Appeal Decision

Appeal Ref: APP/R5510/W/25/3361642

26 Windsor Avenue, Uxbridge, UB10 9AT

- The appeal is made under section 78 of the Town and Country Planning Act 1990 (as amended) against a refusal to grant planning permission.
- The appeal is made by Mr & Mrs Natt against the decision of the Council of the London Borough of Hillingdon.
- The application Ref is 75963/APP/2024/1397.
- The development proposed is part single; part two-storey rear extension to the host dwelling (following demolition of rear extension); part single part two-storey side/rear extension to form an attached new dwelling (following demolition of side extension); raising of overall ridge height; removal of front gable to host dwelling; sub-division of site; hard and soft landscaping; boundary treatment; new vehicular crossover including alterations to the existing parking provision and refuse/cycle storage.

1 LANDSCAPING SITE PLAN - PROPOSED
Scale: 1:200

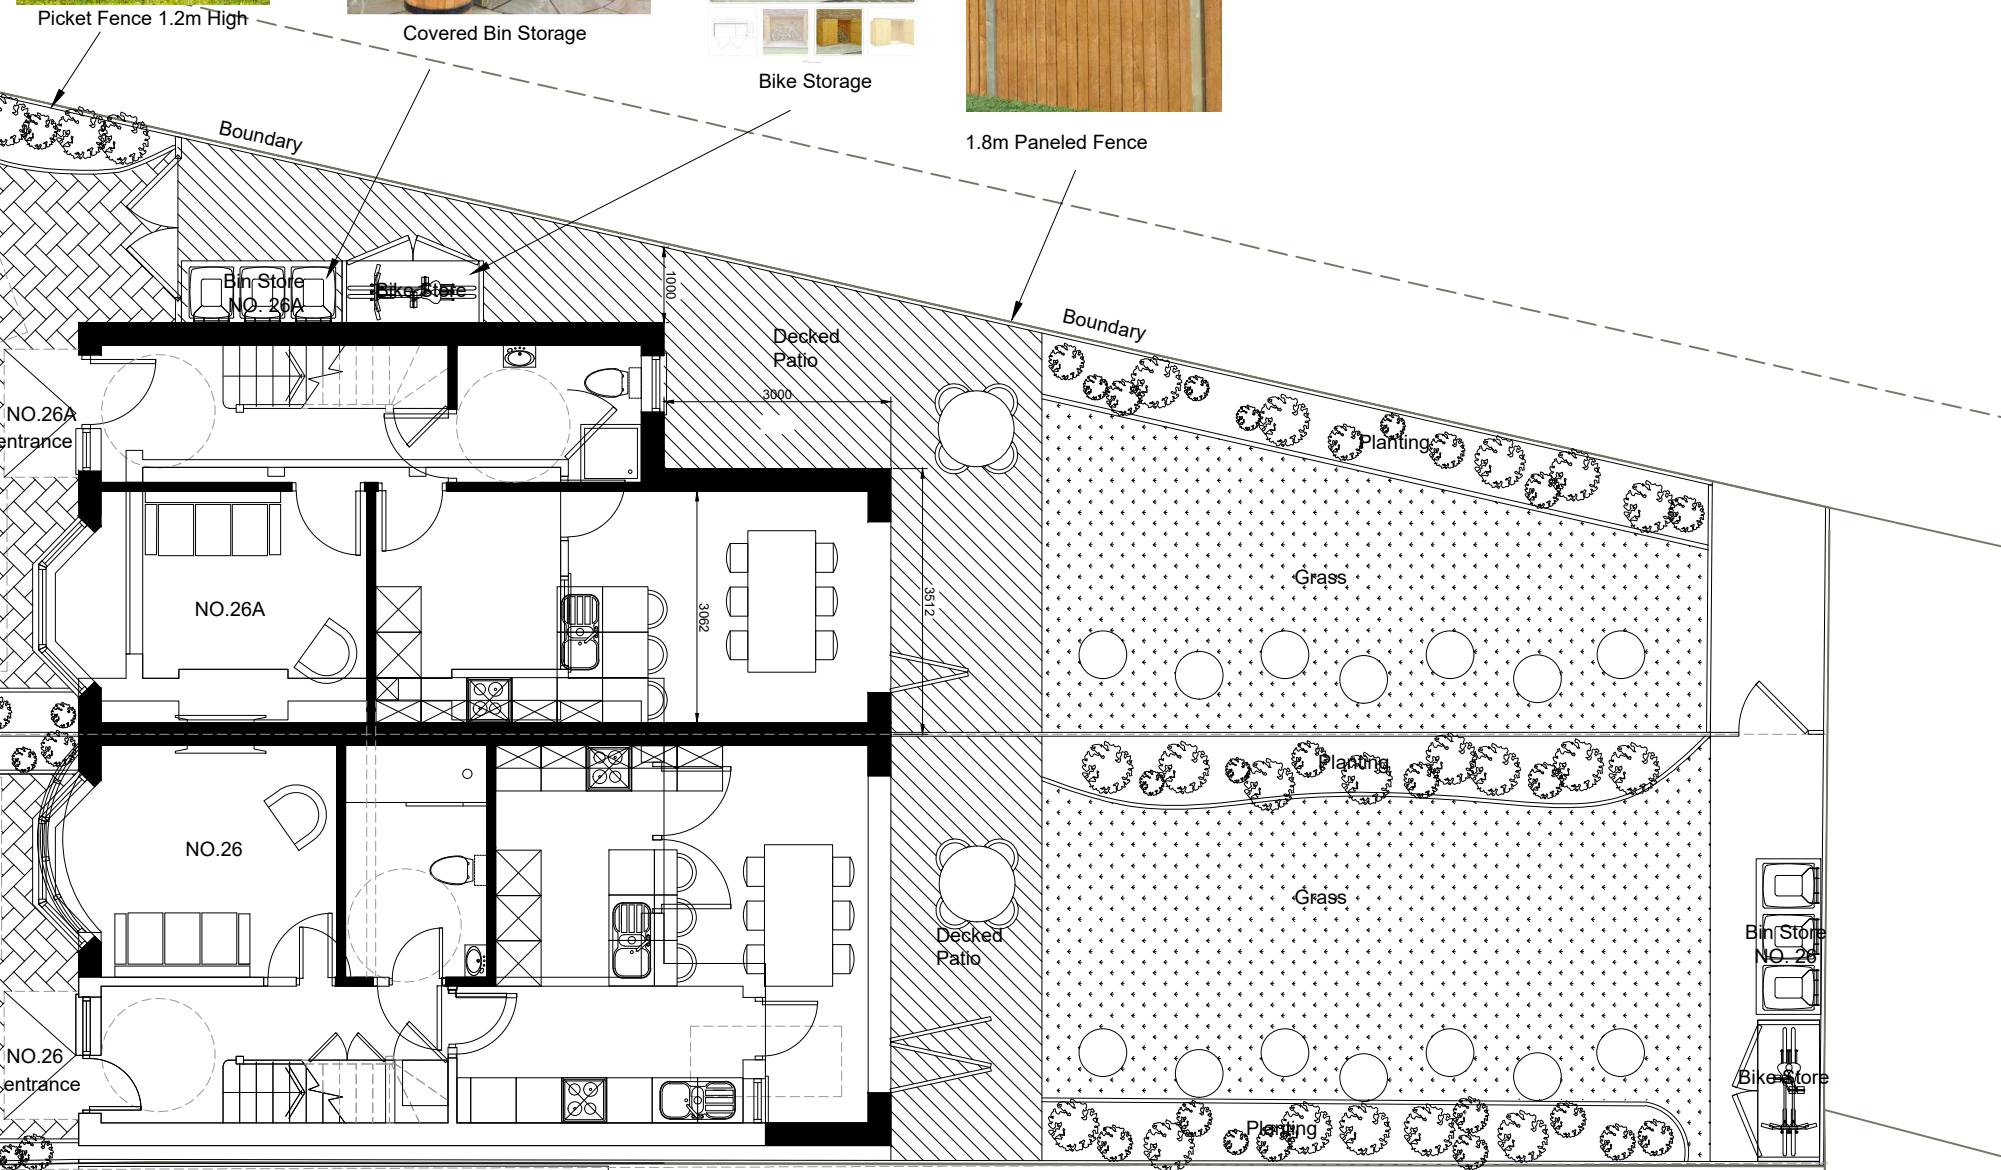
13. The development would result in loss of the open front and side garden of the host property. Although not large, it is bigger than most of the surrounding front gardens, many of which have been lost to parking. It therefore makes a positive contribution to the amenity of the locality even though currently unkempt. The loss of garden area would be partly mitigated through edge planting, but overall harm to the appearance of the area would still be caused.

22. For the avoidance of doubt, the site is not 'brownfield land'. The definition of previously developed land in the National Planning Policy Framework (2024) excludes residential gardens.
23. I note some minor amendments to plans showing pedestrian access into the site and boundary colours in the 'proposed location' plan. As I am dismissing the appeal, I have not considered these further.

PROPOSED ELEVATIONS

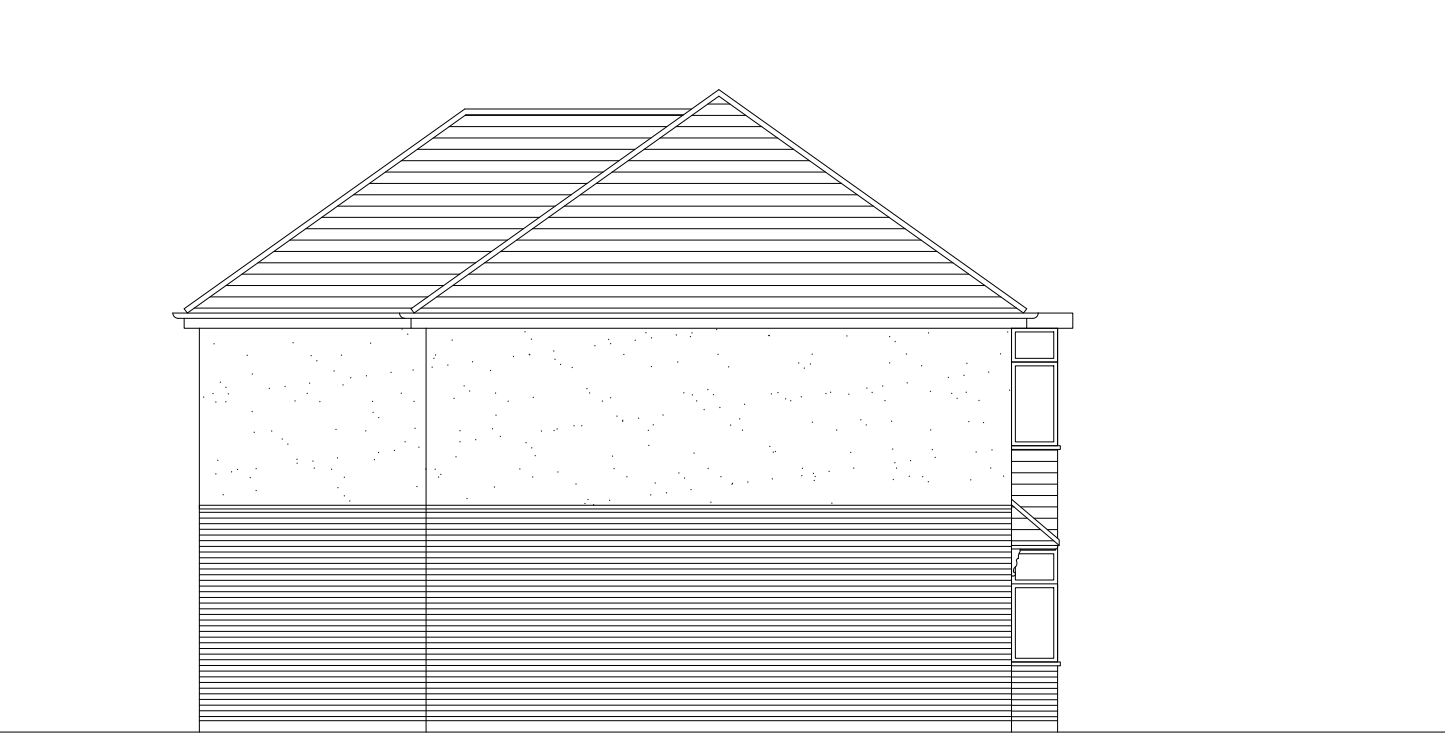
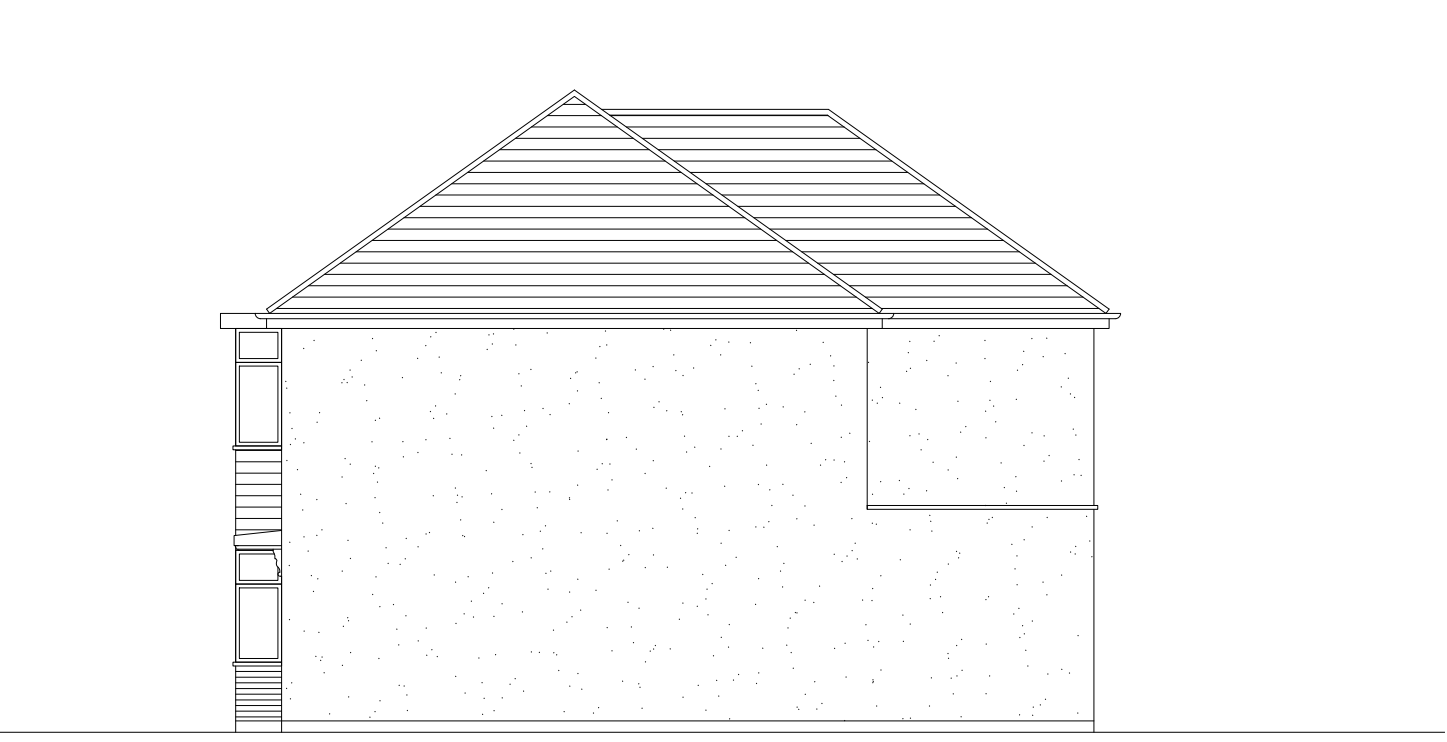
2. It was originally proposed to raise the ridge height of the existing building by approximately 0.5 metres. Amended plans have been submitted at appeal to maintain the current roof height. It is also proposed that one of the bedrooms in 26A Windsor Avenue is reduced in size.

7. The front elevation of the house is dominated by a large, two-storey, curved bay window, above which is an open gable end protruding from a hip roof. The apex above the bay window is decorated with vertical beams. It is proposed that the bay and protruding gable would be removed, and replaced with two shallow, two-storey squared bays with a hip roof across the whole structure.

8. The architecture of the existing building is well proportioned, characteristic of its era and of interest for the varied roof shape, apex decoration and curved bay windows. In contrast, the new building would be of simpler form and the attractive, characteristic points of architectural interest would be lost to the detriment of the appearance of the area.

10. Moving the flank wall of the host building close to the highway would significantly reduce this gap and the sense of openness, and the loss of symmetry would be to the detriment of the character and appearance of the area. In coming to this conclusion, I have had regard to the street scene illustrations provided at appeal.

11. In addition, extending the host building to the extent proposed would noticeably disrupt the strong building line established along Richmond Avenue. The building line is an attractive, positive characteristic of the area and significant disruption to this therefore causes harm.
